DESIGN REVIEW PANEL MEETING # 5

CHAU CHAK WING MUSEUM

Date: Monday 11 September 2017

Drawing Title  
**GENERAL ARRANGEMENT  
PLAN  
ROOF PLAN**

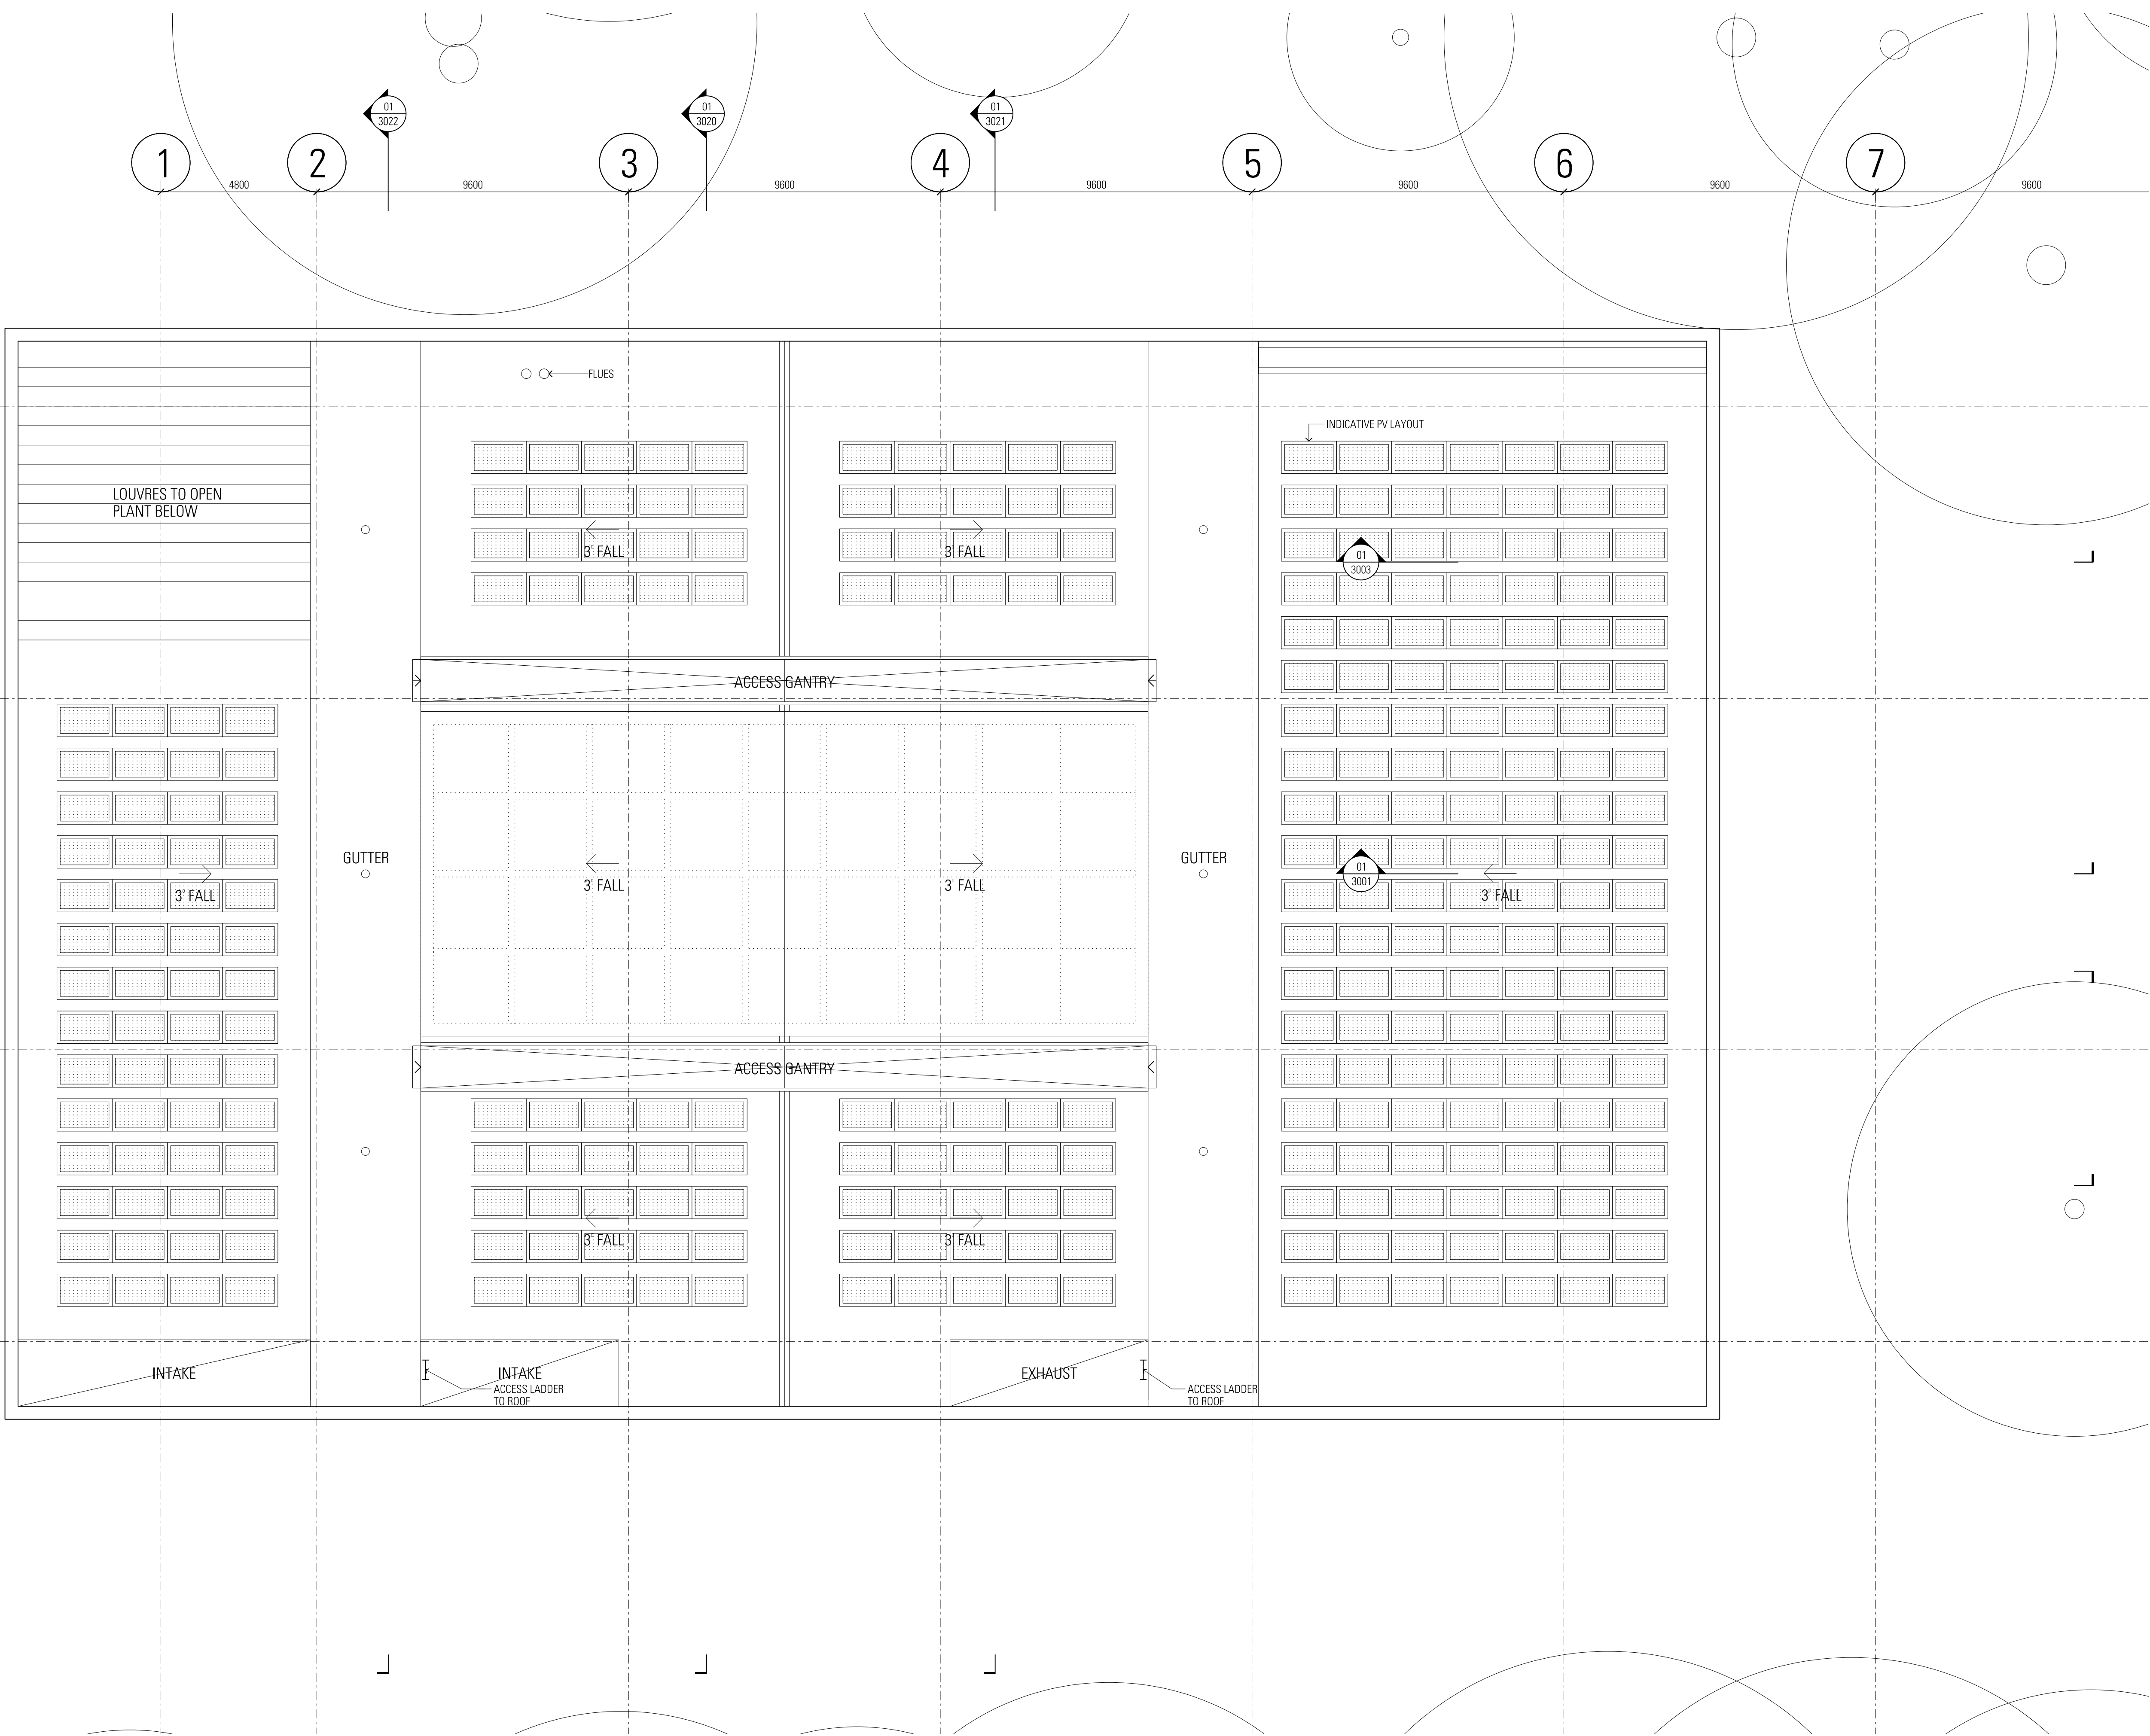
<p><u>Level 5</u></p> <ul style="list-style-type: none"> - Contains plant rooms, arranged as efficiently as possible around the central skylight, with PV cells above.

<p><u>Skylight</u></p> <p>GD presented the current skylight design:</p> <ul style="list-style-type: none"> - a proprietary system – with an insulated thermal IGU – that will produce filtered sunlight with very subtle variations in light quality throughout the day. GD further explained that humans respond to subtle changes in differing daylight conditions. - The 'V' baffles are clad in painted plasterboard - Void above is a heat reservoir, vented to the outside - There will be no direct light entering gallery spaces - Supplementary artificial light is provided above the baffles for night conditions <p>General discussion held regarding the impacts if the skylight was to be replaced with an artificial lantern.</p>	
	<p>MT asked that JPW investigate whether the skylight element should be treated differently from the remainder of the museum internal finishes – different visual 'weight'.</p> <p>PD confirmed that whilst controlled light is critical to protect gallery content, the principle of natural light is good, provided that control is achieved.</p> <p>AC believed that natural light conditions make an average museum a memorable and seductive experience.</p> <p>The DRP recommended that more work be undertaken on the skylight design to make this element an important and special feature of the building, satisfying both Museums (glare and lux level control) and JPW (subtle responses to external daylight conditions).</p>

5.		<u>Resolutions & Endorsements</u> <ol style="list-style-type: none"> 1. The DRP endorsed the current design progression since the earlier concept phase in January 2017. 2. The DRP endorsed the design response to the Heritage Council for the loading dock area as being appropriate and having the least impact on the precinct, and that a future design competition could be initiated for future development to the southern fringe of the site. 3. The DRP endorsed the materiality of the proposed building finishes. 4. The DRP endorsed the current approach of cast-in services to the Level 4 slab only, and if there is an issue when construction documentation is further advanced, then the matter would be referred back to the DRP for resolution. 5. The DRP recommended that more work be undertaken on the skylight design to make this element an important and special feature of the building, satisfying both Museums (glare and lux level control) and JPW (subtle responses to external daylight conditions).

Drawing Title
**GENERAL ARRANGEMENT
PLAN
LOWER GROUND LEVEL - 1**

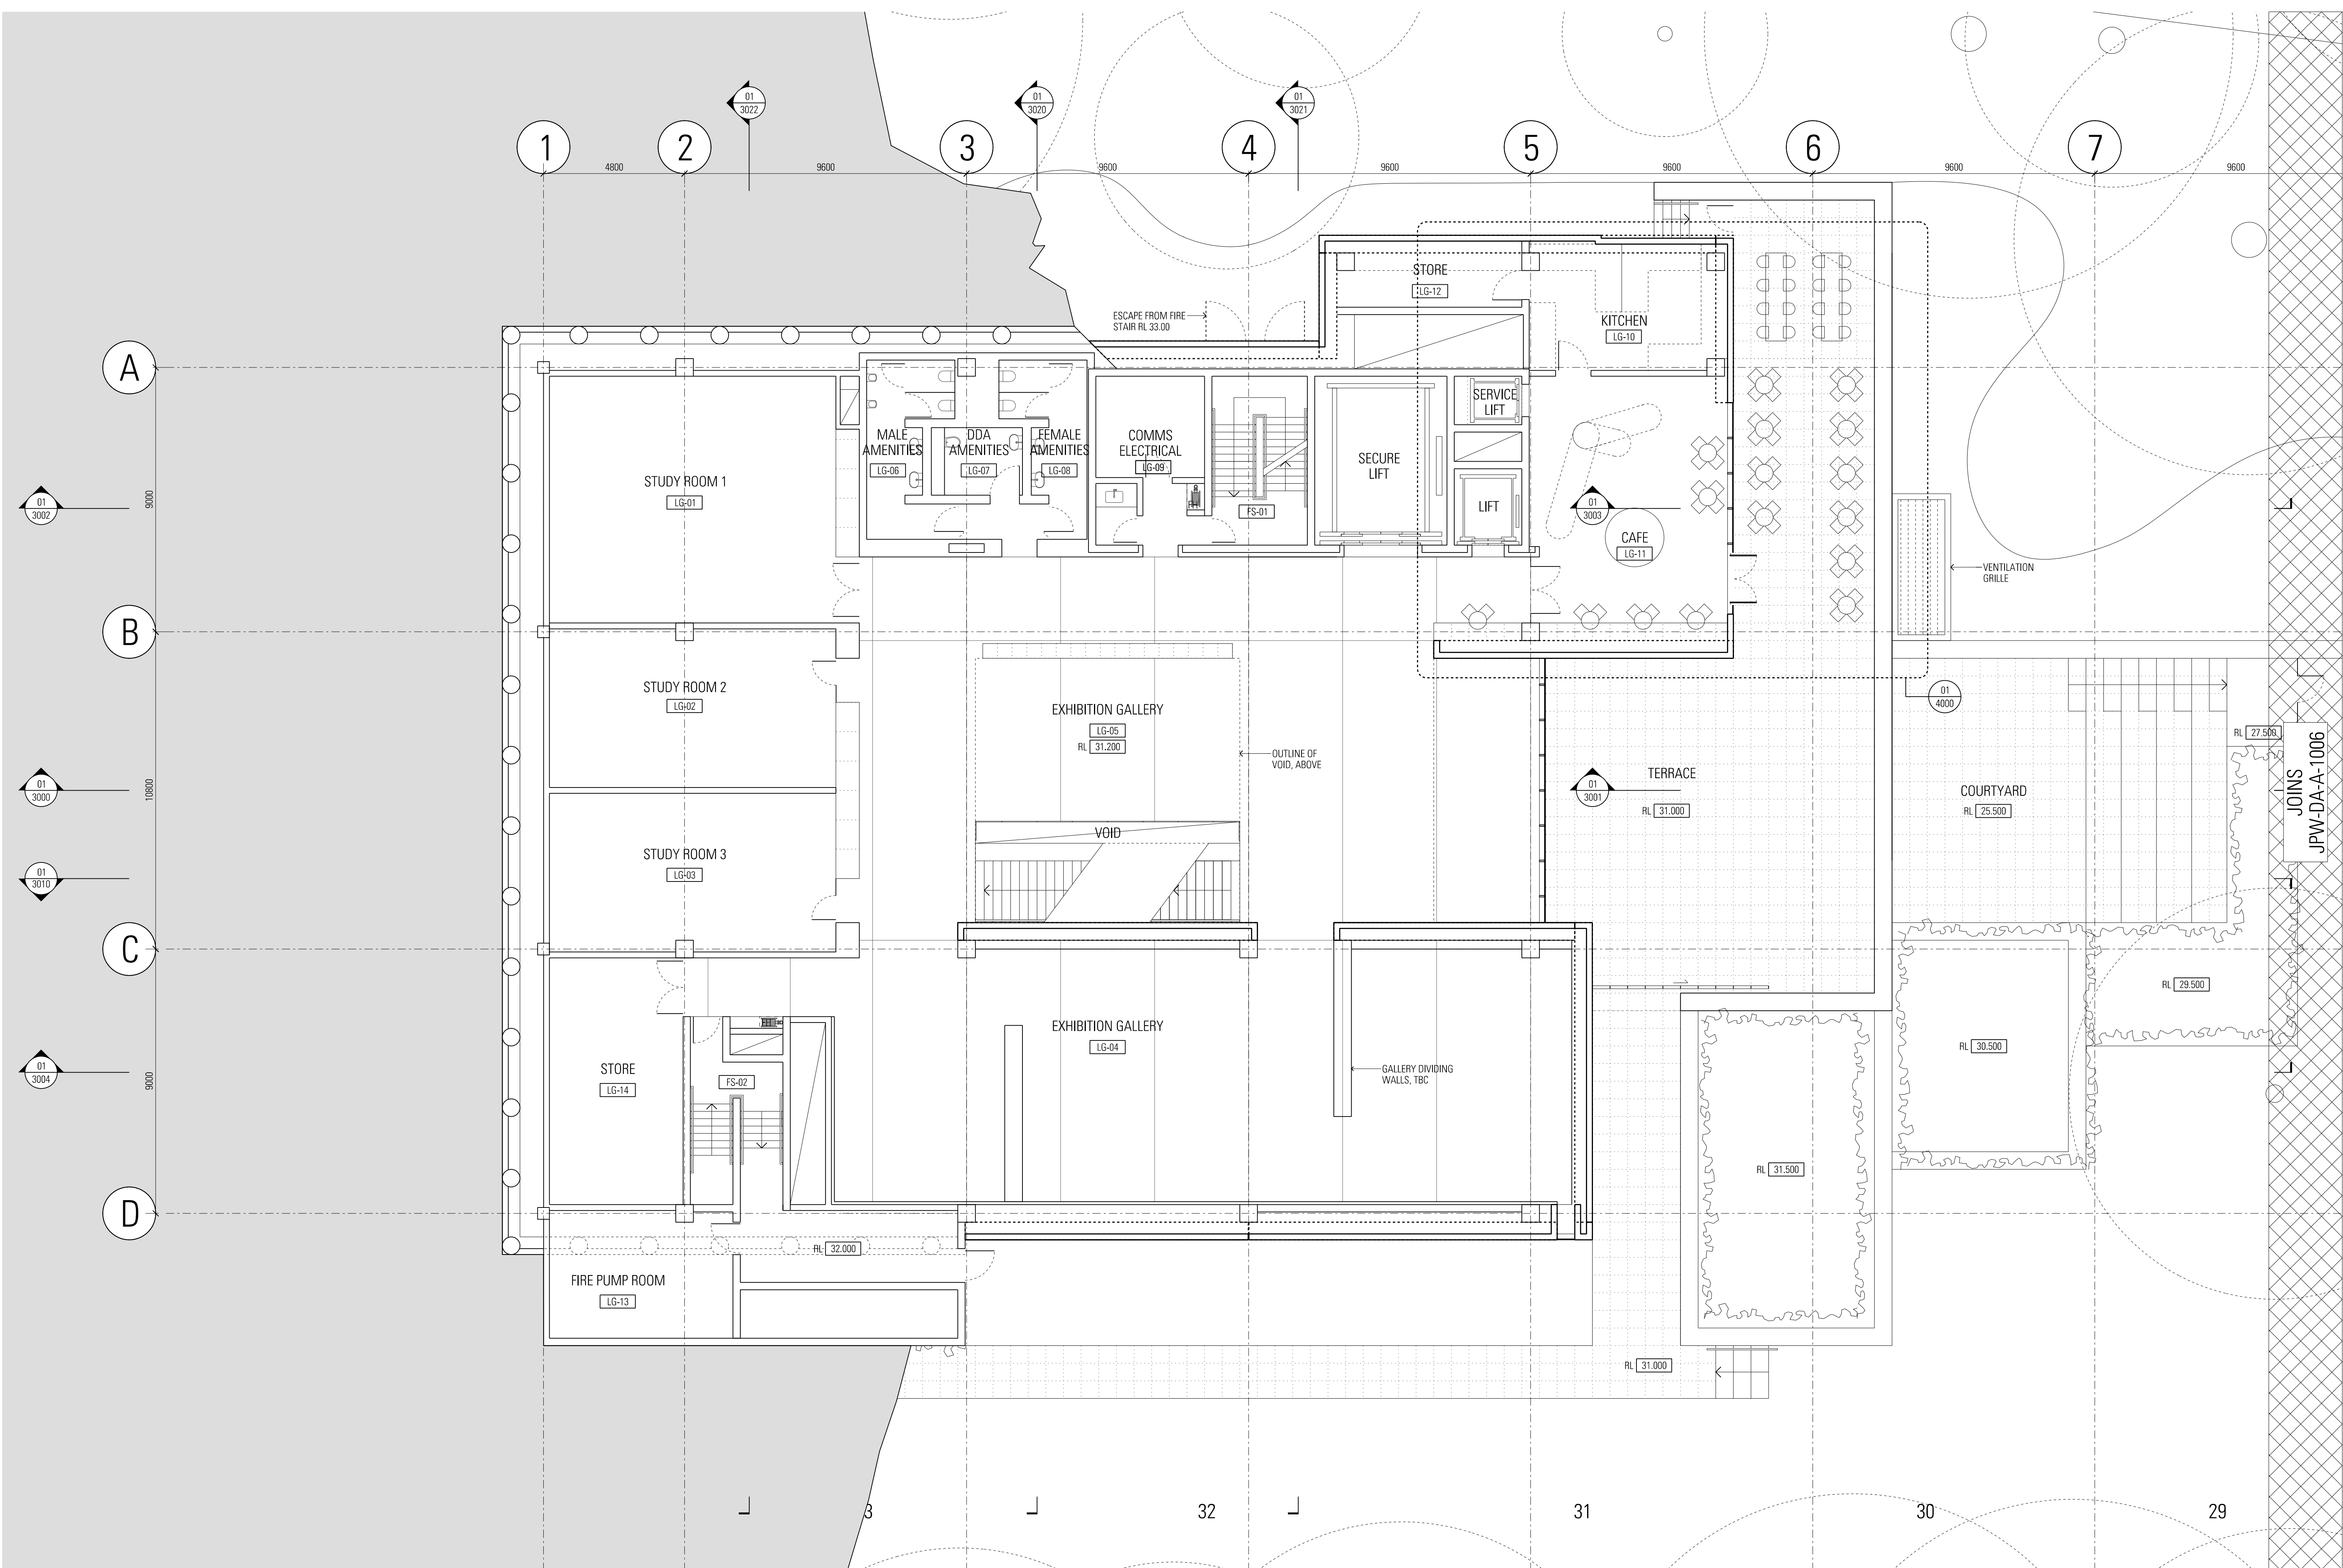
<p>GD presented each level, key points noted as follows:</p> <p><u>Basement 1</u></p> <ul style="list-style-type: none"> - Loading dock entry via ramp from University Place - Collections storage (CERC) with part mezzanine areas - High bay storage - Vertical transportation for exhibits (oversized), passengers, and café are clustered on a single core <p><u>Level 1</u></p> <ul style="list-style-type: none"> - Lowest level of public exhibition - Courtyard off gallery space - Circulation around galleries brings the visitor back to the central stair
